**THANET FISHERMEN'S ASSOCIATION.**

**Thanet Extension Offshore Windfarm. Planning Inspectorate-Application by Vattenfall Wind Power Ltd for an Order Granting Development Consent.**

**Thanet Fishermen's Association Written Representation.**

Figure 3.9 Driftnetting fishing grounds identified during TFA consultation (indicative layout) (Source TFA: 2016)

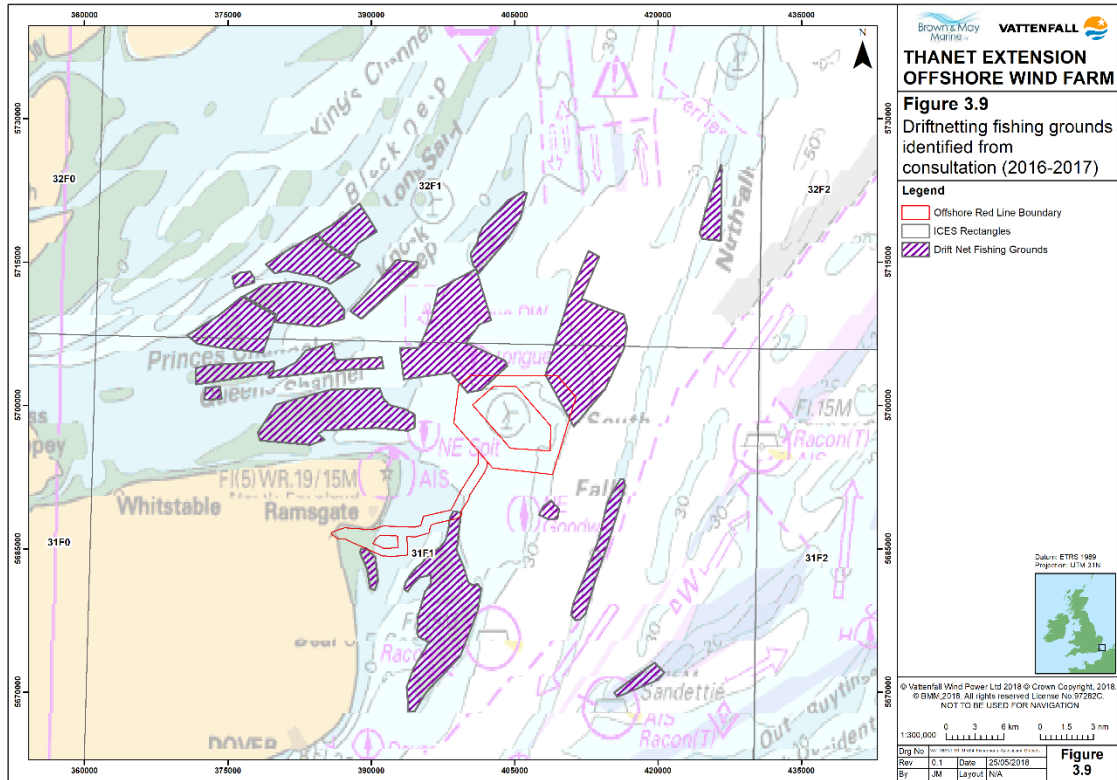
**3.3.3 Fishing Grounds -Figure 3.9 Driftnetting fishing grounds identified during TFA consultation (indicative layout) (Source TFA: 2016)**

**TFA Comment:** The indicative layout suggests that the drift grounds within the TE RLB are very small compared to the numbers of drift grounds overall. As stated in ES table 9.4, there needs to be distinction between surface and bottom drift grounds rather than a combination of the two and this needs to be worked on in conjunction with TFA. However, due to the various influences on both forms of drift grounds, this is not straight forward. The paper charts completed by the Fishermen in 2016 to show how different areas were fished, were also indicative as bottom drifts are often small areas within a larger footprint. Notably also, the Eastern bottom drifts within the RLB, are not shown on this chart. These drifts are particularly productive at times and were noted during the Thanet Extension surveys in 2016. What a chart like this cannot show is the frequency with which each drift is used, which may change on an annual basis dependant on availability of species/ weather/quota/ legislation etc. The Succorfish data, though limited, already gives some indication of frequency of use on particular grounds.

Figure 3.12 Average landing values (2012-2016) by species and method in ICES rectangle 31F1 (source: MMO, 2018)

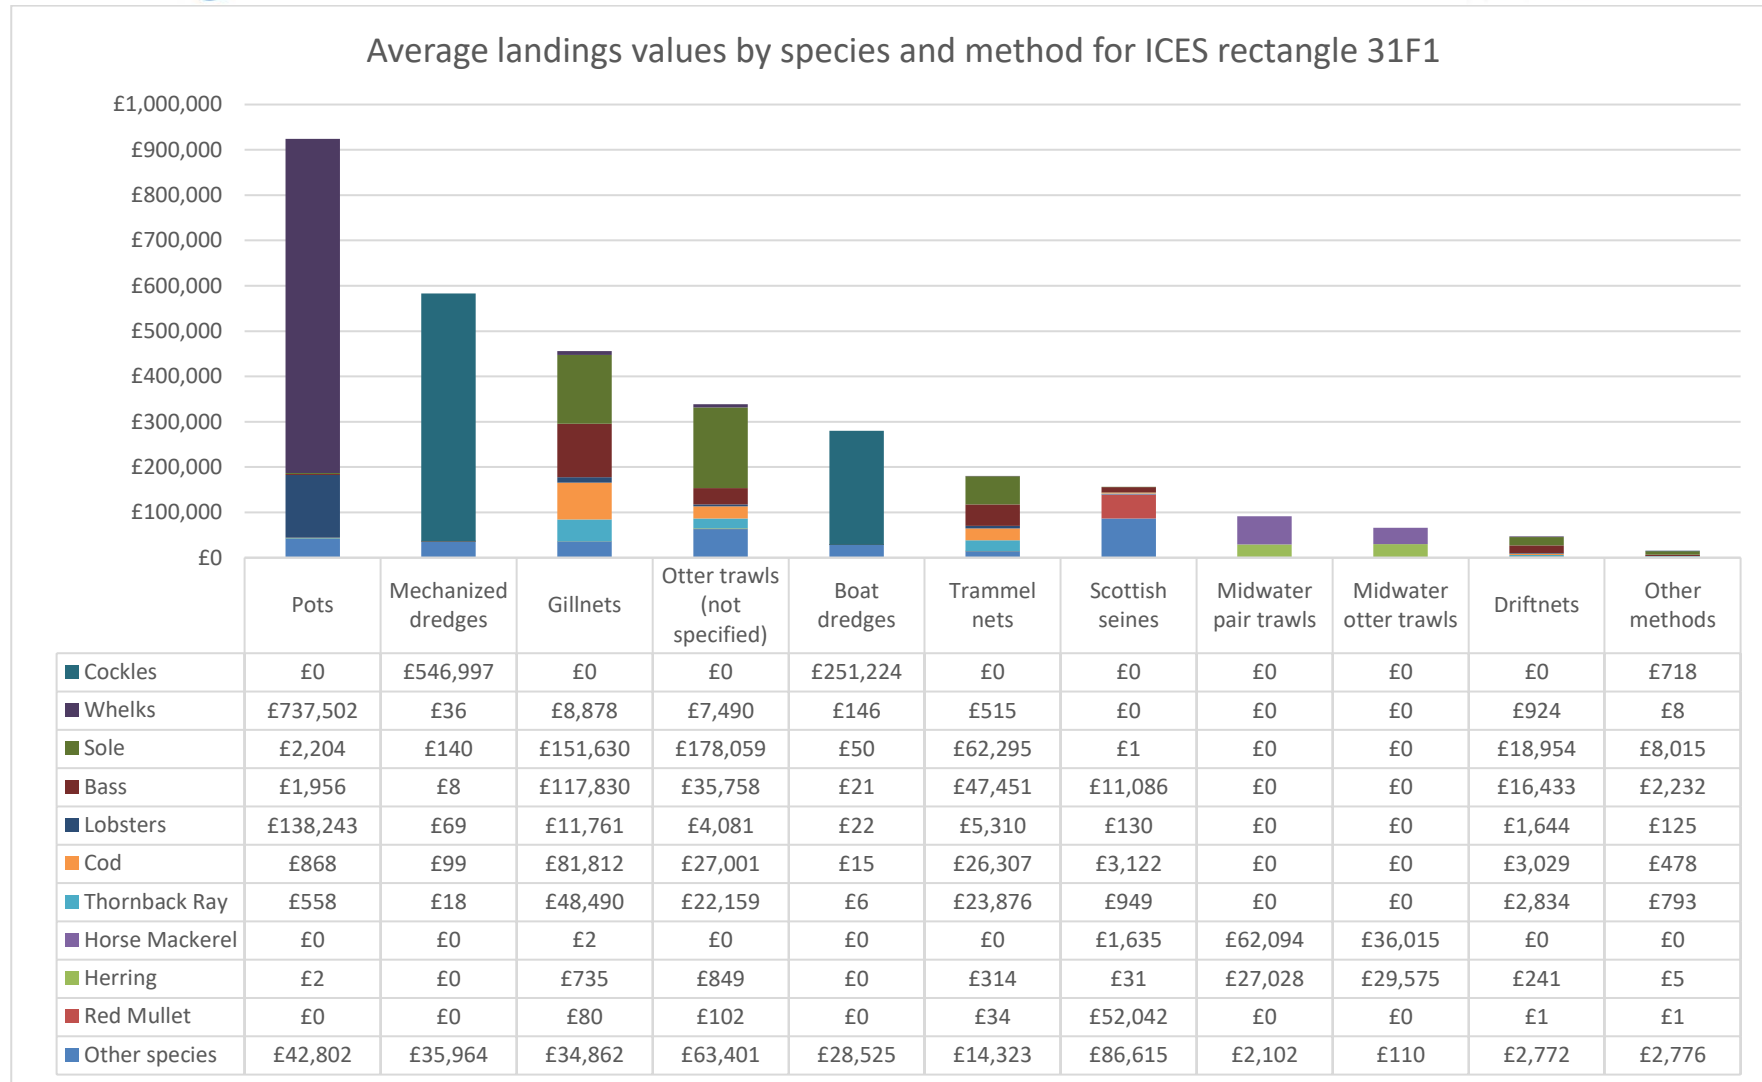
**3.3.4 UK Landings Data (page 30) Figure 3.12 Average landing values (2012-2016) by species and method in ICES rectangle 31F1 (source: MMO, 2018)**

As agreed in the SoCG, this is based upon best available data and on ICES rectangle data coupled with the overflight data. The financial/method breakdown cannot be correct if the inshore fleet are included in this table. The total landings values for drift nets are wholly inaccurate for the under 10's for ICES 31F1, the vast majority of Dover Sole landed in Ramsgate is by drift net, one of the Ramsgate vessels alone exceeds the figure stated for drift nets (£ 18,954), again in figure 3.13, the 10m & under division of value by method is incorrect, although the landings figures quoted in the commercial fisheries annex for Ramsgate and Whitstable seem correct. The Buyers and Sellers landing declaration for the under 10 fleet does not require the method by which the fish was caught to be noted, so how this data has been allocated to a particular method is unknown. The inaccuracies in this data are very relevant to the TFA Fishermen and for the benefit of this report are being used to assist ascertaining impact. Drifting is a key method for TFA, If the data is incorrect, the impacts concluded from that data are unlikely to be correct.

Figure 3.17 UK Surveillance sightings by method in the vicinity of the proposed development (indicative layout) (2012-2016); (Source: MMO,2018)

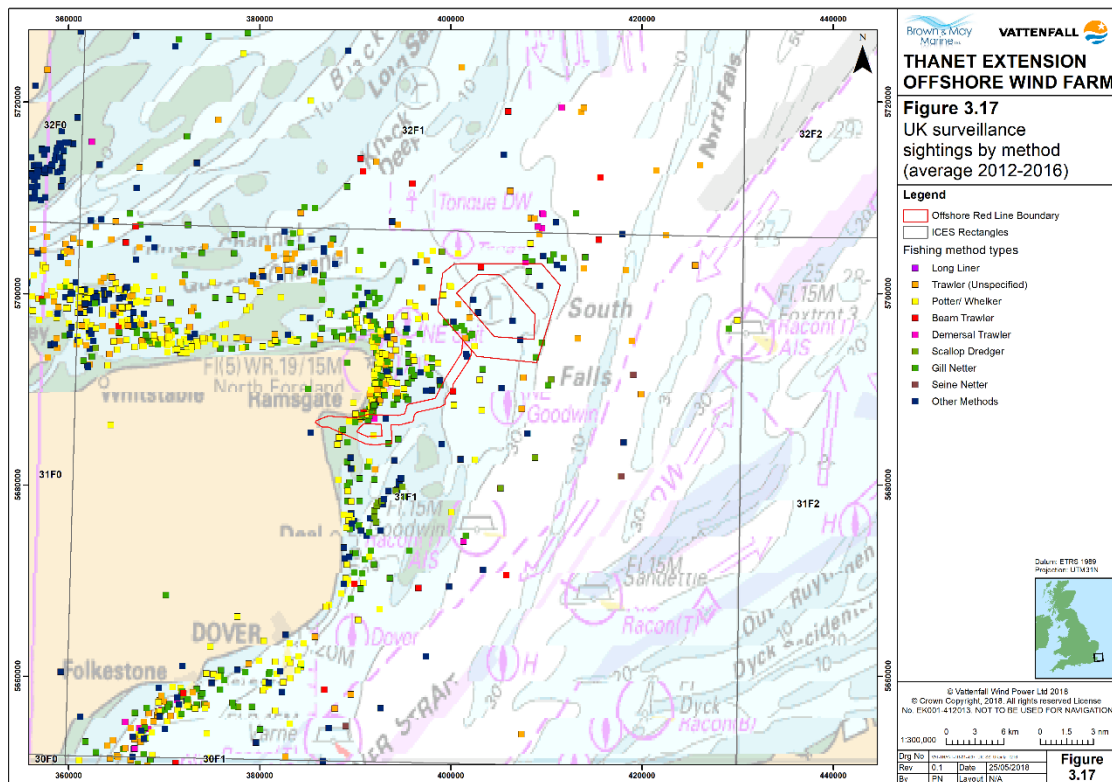
**3.3.7 Surveillance Sightings (Page 38) Figure 3.17 UK Surveillance sightings by method in the vicinity of the proposed development (indicative layout) (2012-2016); (Source: MMO,2018)**

We anticipate this is the overflight surveillance and IFCA vessel visual surveillance data. The offshore annex in the PEIR on commercial Fisheries indicates that the overflights are undertaken weekly, but we are not convinced that this is the case. We would question how this data was interpreted, the chart does not differentiate between vessels that are steaming and vessels that are fishing. While the IFCA may be able to differentiate between vessels by method visually at times (local knowledge), overflights are very unlikely to be able to do so. The high intensity of green Gill netter sightings near the shore would suggest these vessels are steaming elsewhere, as there are no drift grounds along the shore, and potters are shown independently

in yellow. We would seriously question the validity of the surveillance data in connection with the inshore fleet. We anticipate there is no surveillance at night, either by IFCA patrol vessel or overflight, or during the early hours of the morning. In the context of the Thanet Extension project, figure 3.17 can be misleading as it shows very intense fishing against the shore, largely by potters, and suggests far less activity offshore, especially around the TOW and proposed TE area. In reality, the netters outnumber the potters, and the potting supposedly illustrated between Ramsgate and Margate in yellow, is largely undertaken by three vessels. We anticipate that one of the reasons there are more sightings of netters, shown in green, near the shore is because they are IFCA patrol vessel sightings and the IFCA vessel mainly patrols inside the 6 mile limit where it has full jurisdiction. The way this data has been collected, and shown, cannot be used to represent effort at the proposed TE site.

Figure 3.21 Vessel tracks for April 2017 as recorded by portable trackers (Succorfish Ltd.)

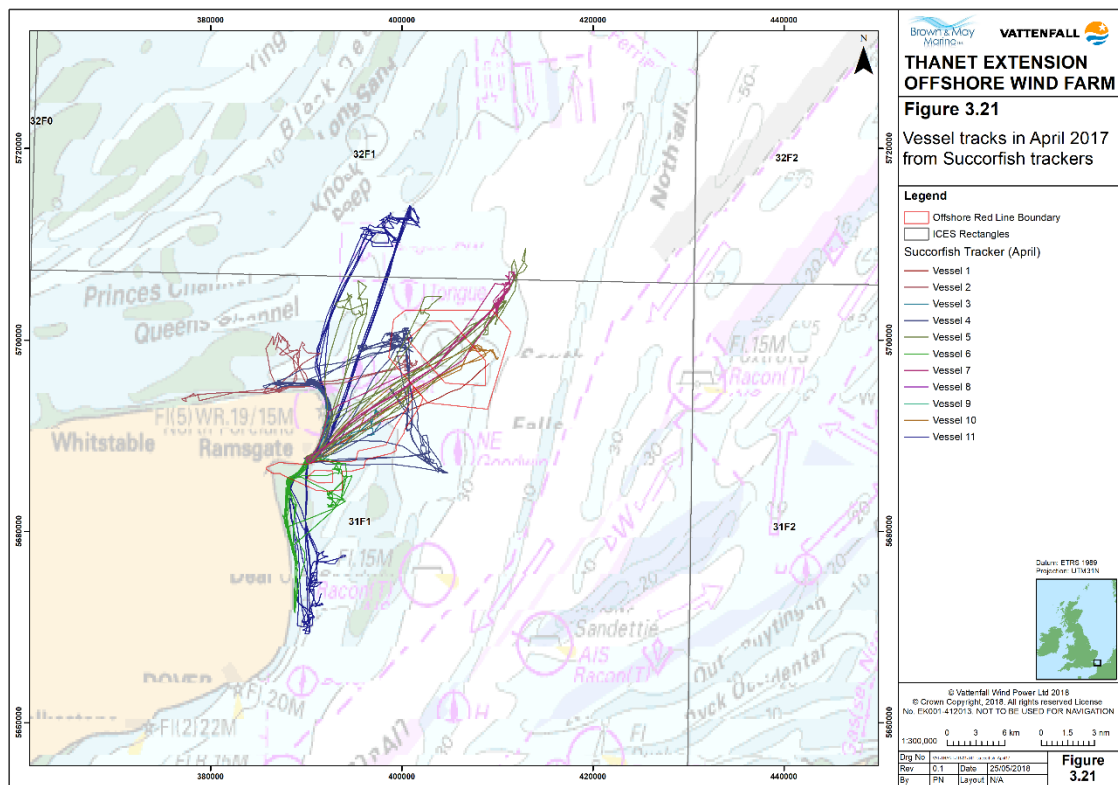
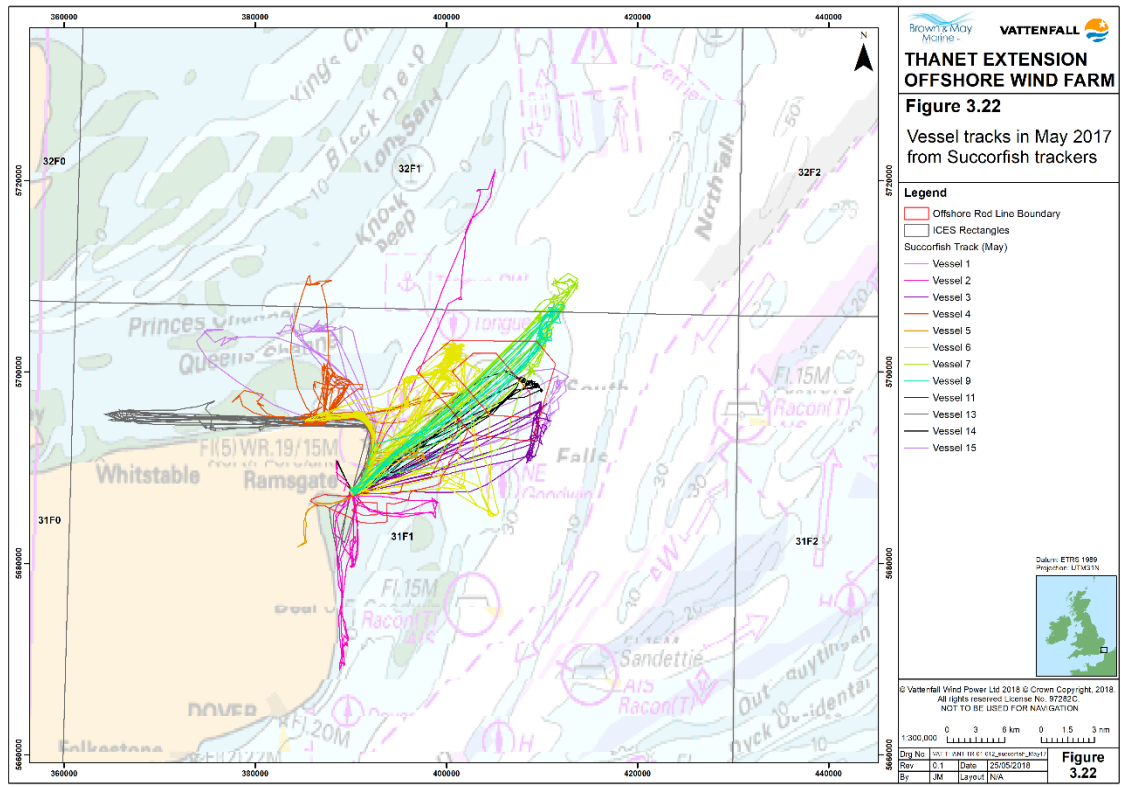
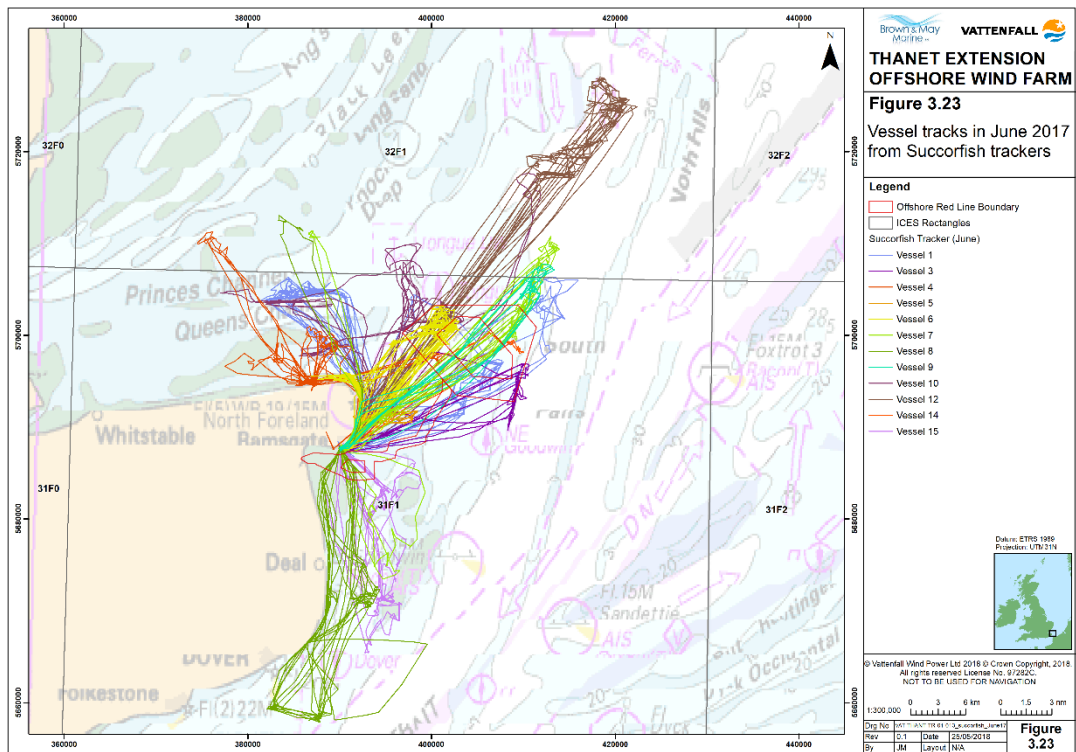
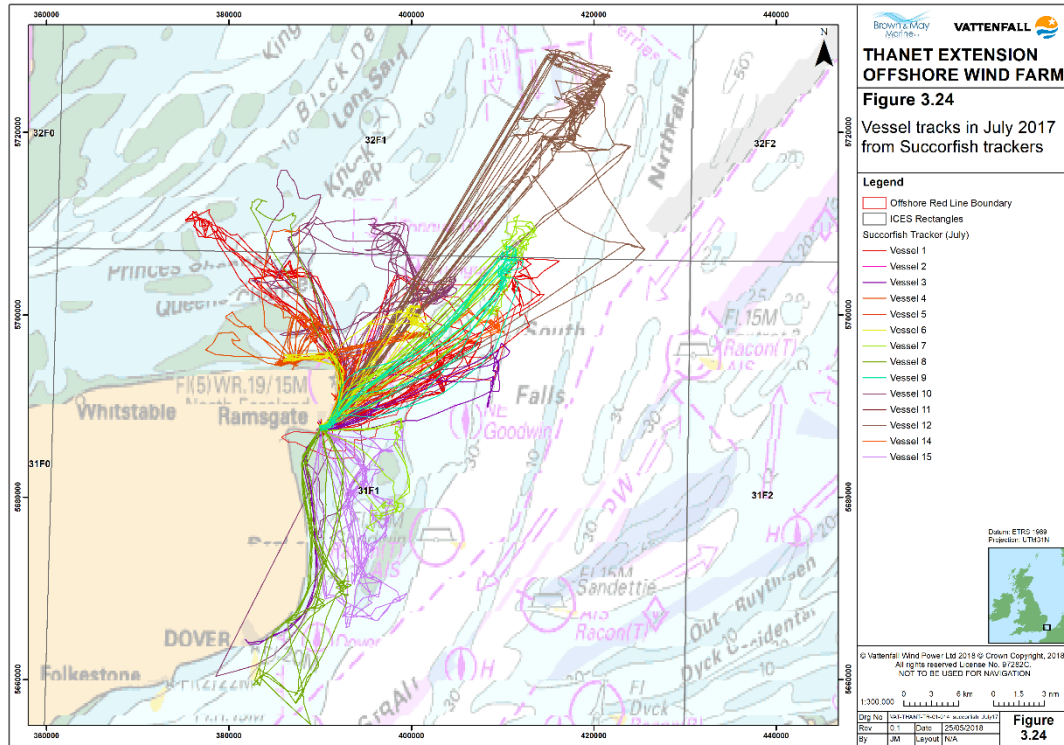
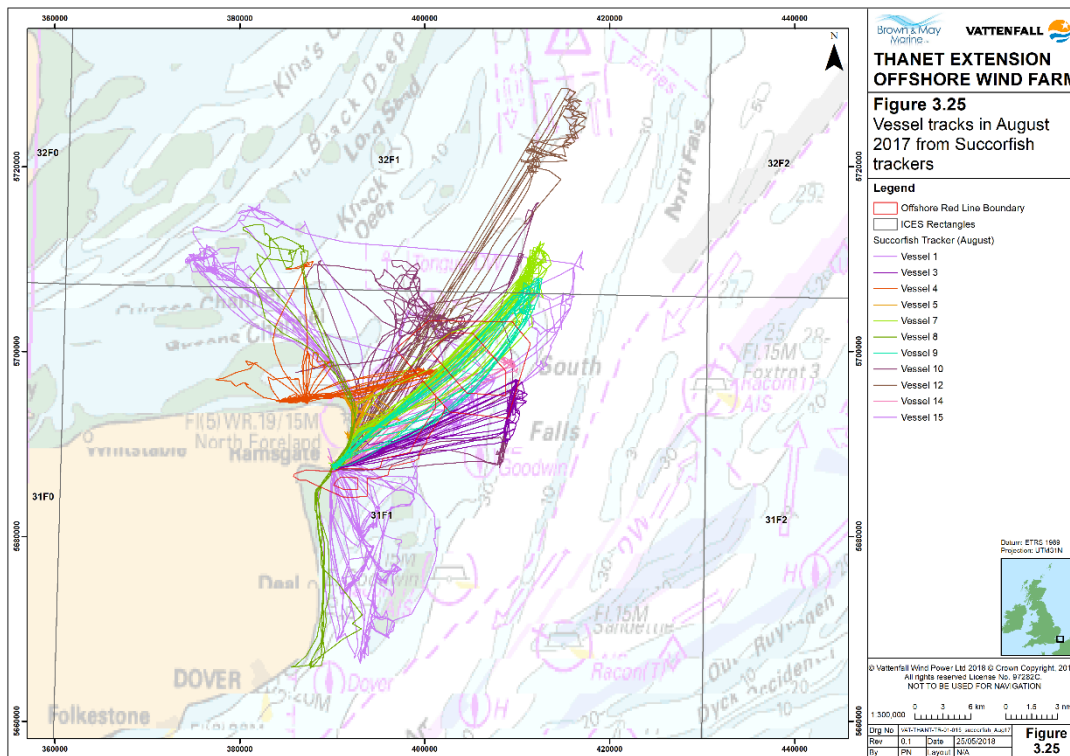
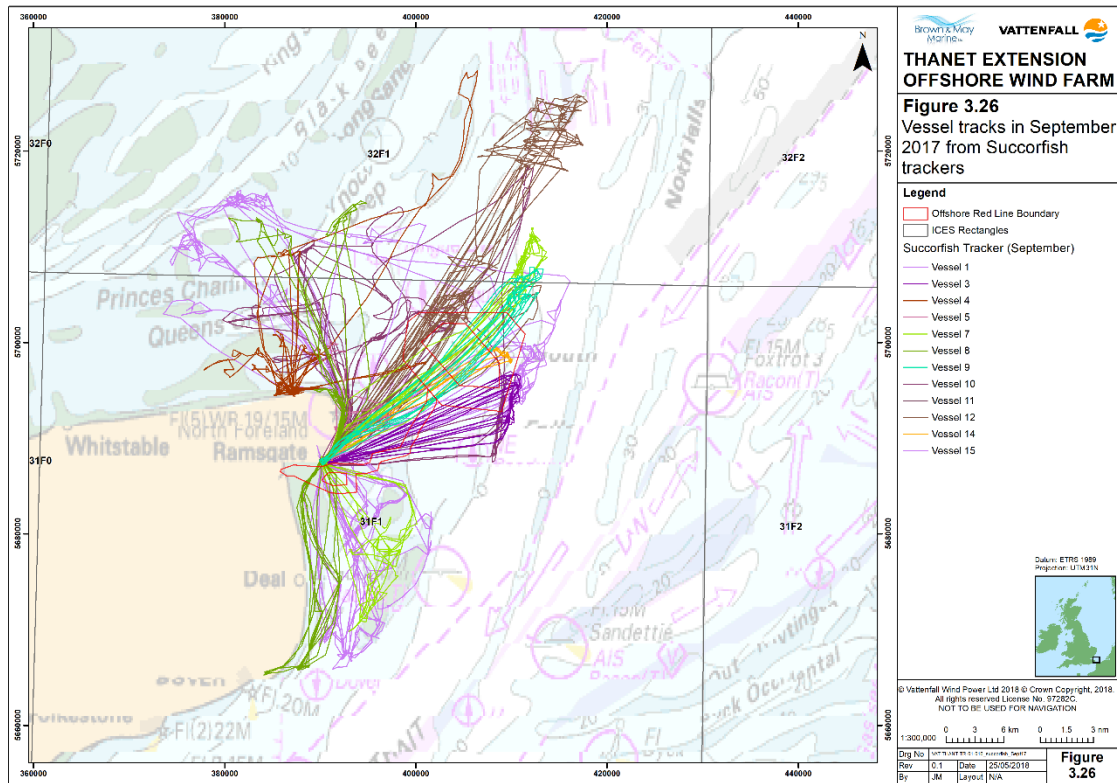
**Page 42, paragraph 2. *The Succorfish data shows that vessels use the proposed development area to varying degrees. This data has confirmed that vessels have alternative grounds in the vicinity of the proposed development and that it is primarily used as a transit route rather than fishing ground. The data also shows vessels are able to fish and steam through the existing TOWF.***

Taking the paragraph above from 3.3.9 in three parts, we would partially support the statement that the TE proposed area is used primarily as a transit route, because it is the pathway to a number of grounds within the Red Line boundary, within the TOW windfarm, around it and beyond it. Succorfish, even with the breakdowns in continuity, does clearly show that the proposed TE area and the current TOW windfarm are used regularly by Fishermen for transit, highlighting the impact that would be felt should these routes be restricted or closed.

What we would not support is the suggestion that the proposed development area is primarily used as a transit route 'rather' than a fishing ground. In the nine Figures 3.21 to 3.29, the Succorfish tracks and course alterations of vessels in each figure show at least 4 and up to seven, vessels working within the RLB rather than making a transit through it. Bearing in mind a maximum of 15 vessels are being tracked, this shows the extent to which these vessels use the proposed development area and the TOW windfarm.
